<input type="checkbox"/> Sidewalk Waiver (Form V2)		
<b>SITE PLANS</b>		<input type="checkbox"/> Waiver to IDO (Form V2)	<b>APPEAL</b>
<input checked="" type="checkbox"/> DRB Site Plan (Form P2)	<input type="checkbox"/> Waiver to DPM (Form V2)	<input type="checkbox"/> Decision of DRB (Form A)	
<b>BRIEF DESCRIPTION OF REQUEST</b>			
Apartment complex development

**RE: Sonata Unit 4 Trails Apartments  
Tracts 1, 2, and 3, The Trails Unit 4  
Second DRB Submittal**

RESPEC, agent for Sonata Trails, LLC, owner of the above referenced property, is requesting approval from the Development Review Board (DRB) on this Site Development Plan submitted for your consideration. This is the second submittal to the DRB for this project. The first hearing was held on June 3, 2020. Below is a response to comments received at the first DRB meeting.

PROJECT NAME:
SONATA TRAILS UNIT 4 APARTMENTS

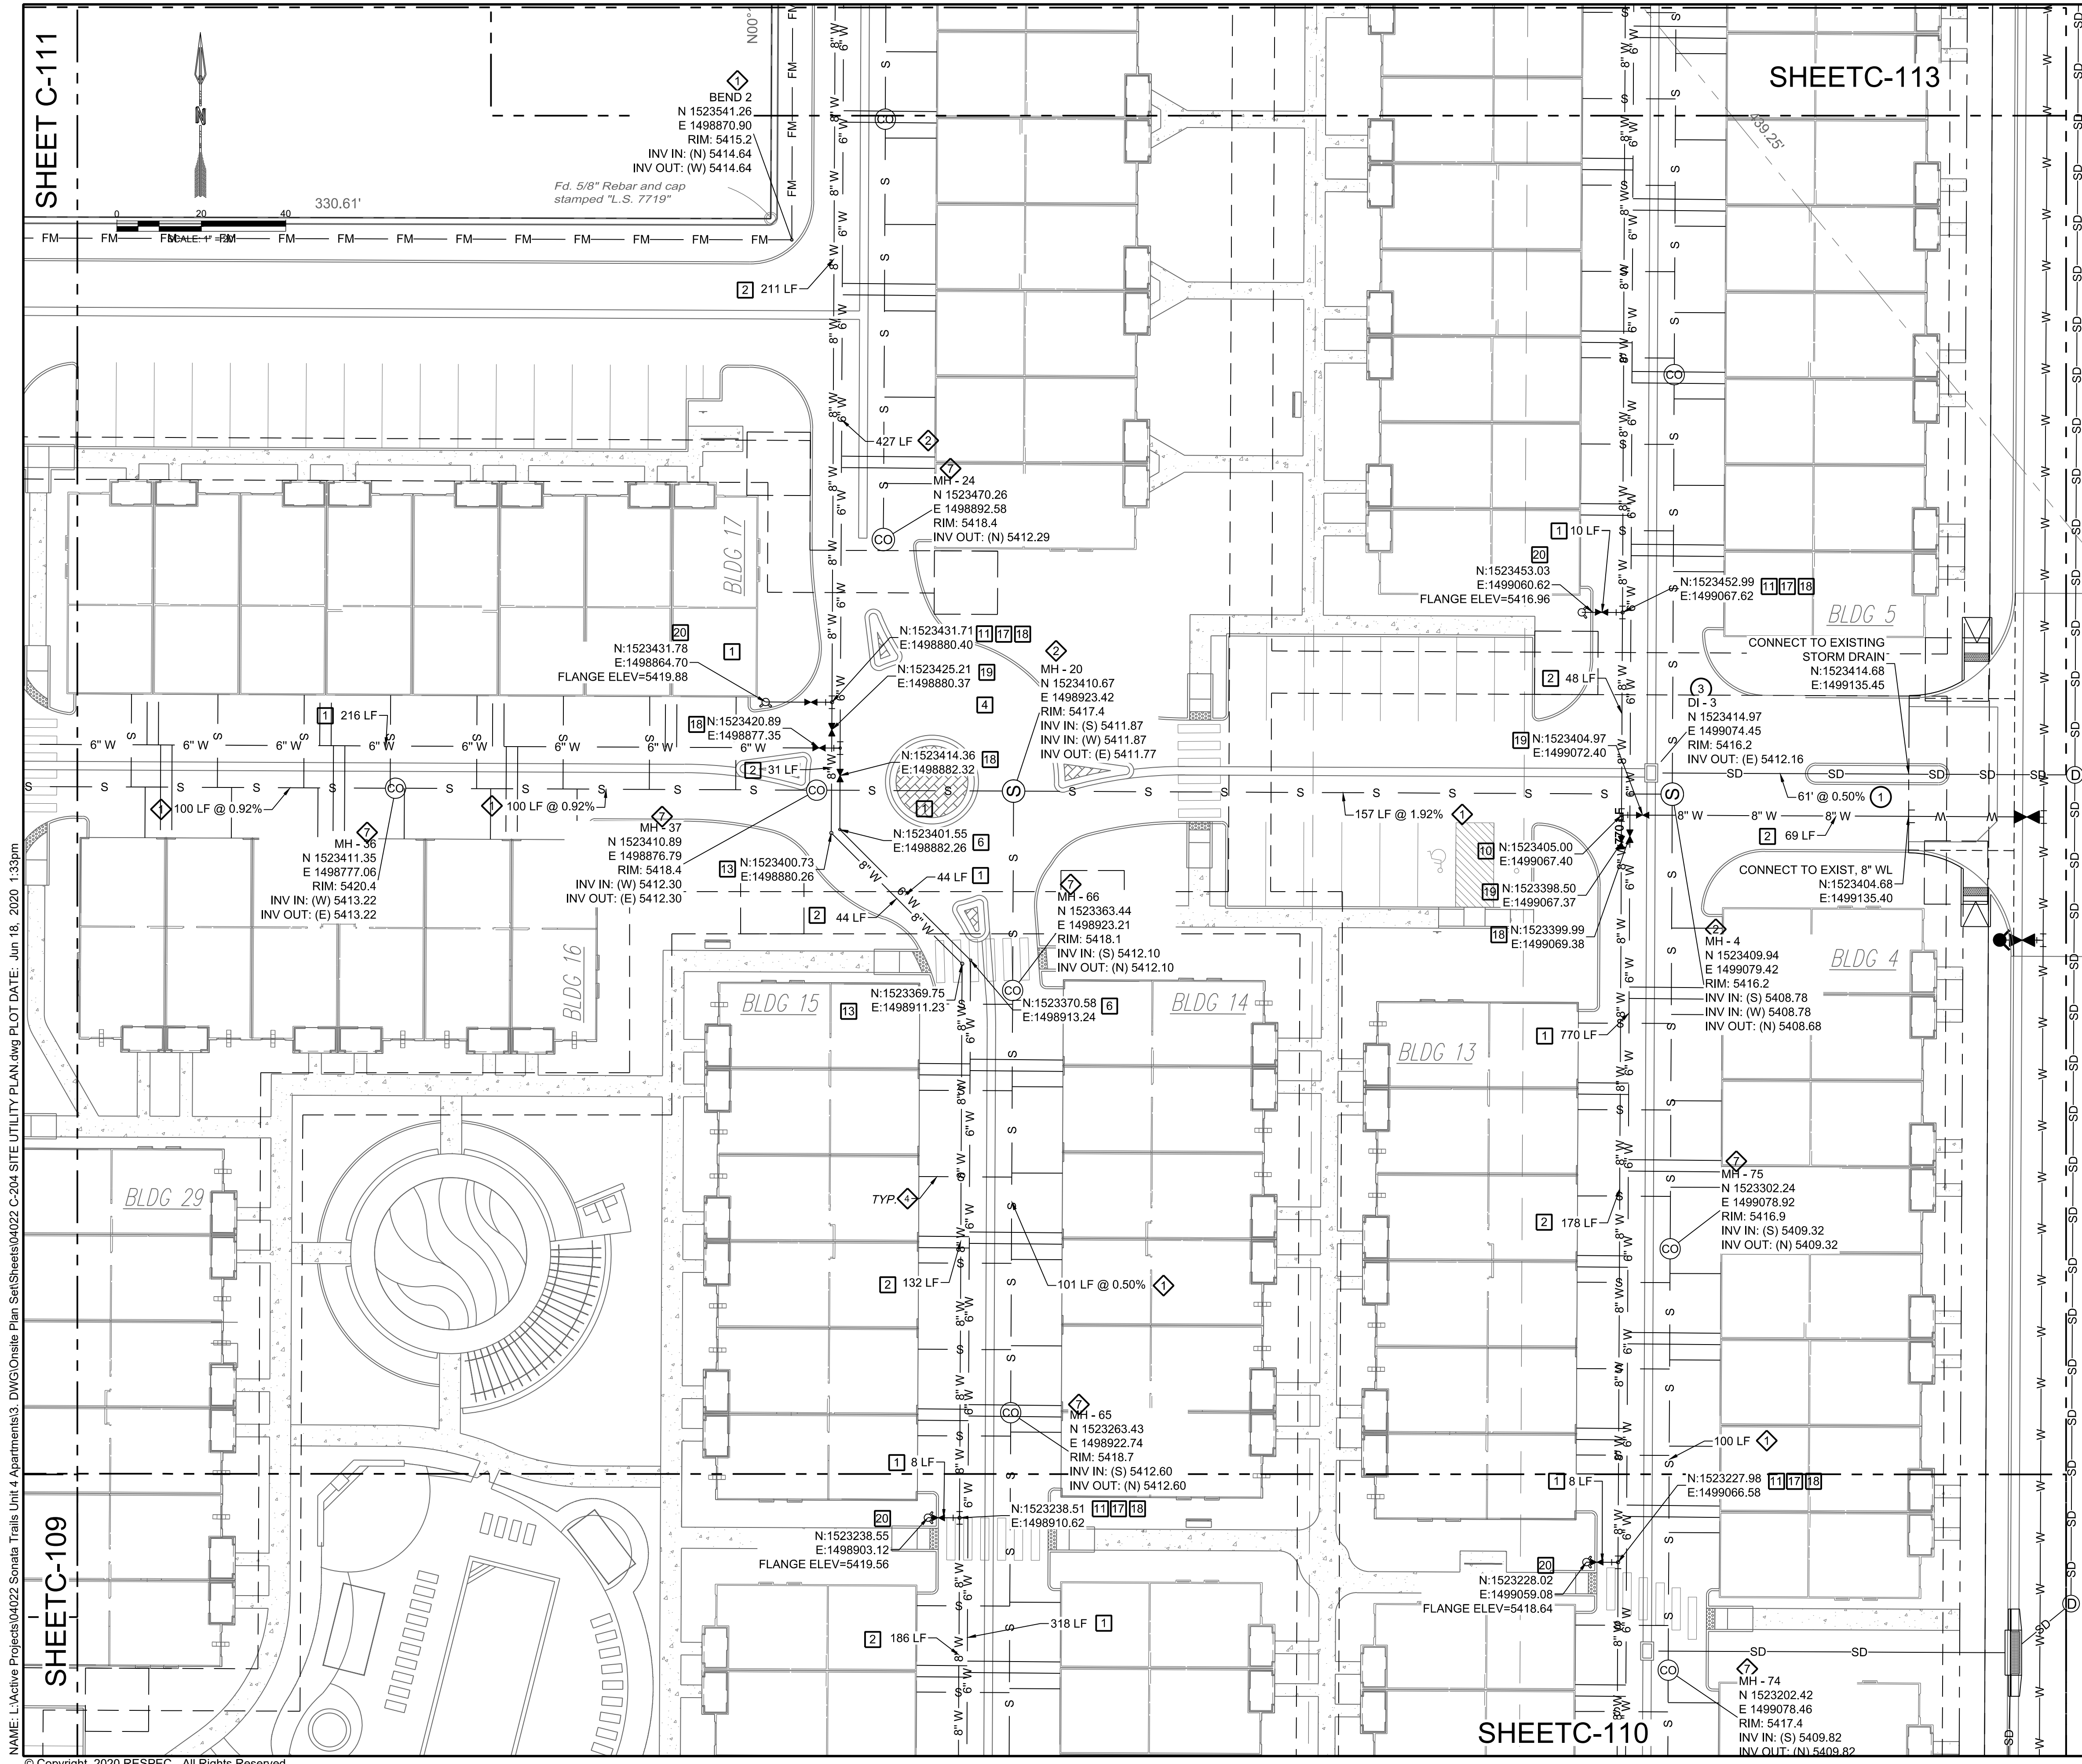
3. Utility Plan
    - a. A meter is shown for each unit. This is not consistent with a previous proposal for a previous request for availability statement which included master meters for the entire development. The proposal for individual meters for each unit (which is not consistent with the calculation for UECs in the Rate Ordinance) appears to be significantly more costly.

- i. The onsite public waterline can be minimized depending on the outcome of metered service locations. The apartment complex can be served by either a master meter or a combination of meters to serve buildings.

- b. Coordination with the engineer is taking place to understand the best routing of sanitary sewer for the subject development as it has an impact on the surrounding area. The alignment along Chatsworth Dr. is being researched to better understand a potential high point and ability for adjacent properties to discharge to this line.

- c. A proposed lift station is shown at the northwest corner of the subject development which ultimately discharges to proposed public gravity sanitary sewer along Treeline Ave.

- i. Considering the potential interim condition with the private lift station, the Utility Plan should show the phases.
      1. The interim use of a private lift station and the trigger to eliminate the private lift station and discharge to public sanitary sewer that flows to the proposed interceptor along Paseo Del Norte/Avenida De Jaimito

when it is available may need to be detailed in the development agreement.

- 1. Public sanitary sewer along Treeline Ave. that flows east is not shown on the Utility Plan.
- / If I remember correctly, a public sewer in Tree Line was not required in the previous serviceability statement. Will this be a requirement with the new serviceability letter? If so, who will this sewer serve? No change has been made to the utility sheets.

- e. Public waterline and sanitary sewer along the frontages of Treeline Ave. and Chatsworth Dr. are not shown to be proposed on the Utility Plan.
- / Public waterline and sewer are shown in Chatsworth Dr. and public waterline is shown in Tree Line Ave. See revised utility sheets.

- f. Label proposed lift station and onsite sanitary sewer as private (both force main and gravity sewer). Based on the determination of the onsite waterline, public waterline and private waterline shall be labeled as well.

- / The meters for each unit have been removed. We are proposing a master meter at the southeast corner of the development. See revised utility sheets.**

- / Detail has been added to demonstrate the phases for the private sanitary sewer. See revised utility sheets, specifically C-113.
  - d. Please confirm if the proposed manhole south of existing manhole C10302 can be eliminated by extending east directly from the existing manhole along Treeline Ave.

- / All utilities on-site will be private and all utilities within the right-of way will be public. See revised note 13 on sheet C-108.
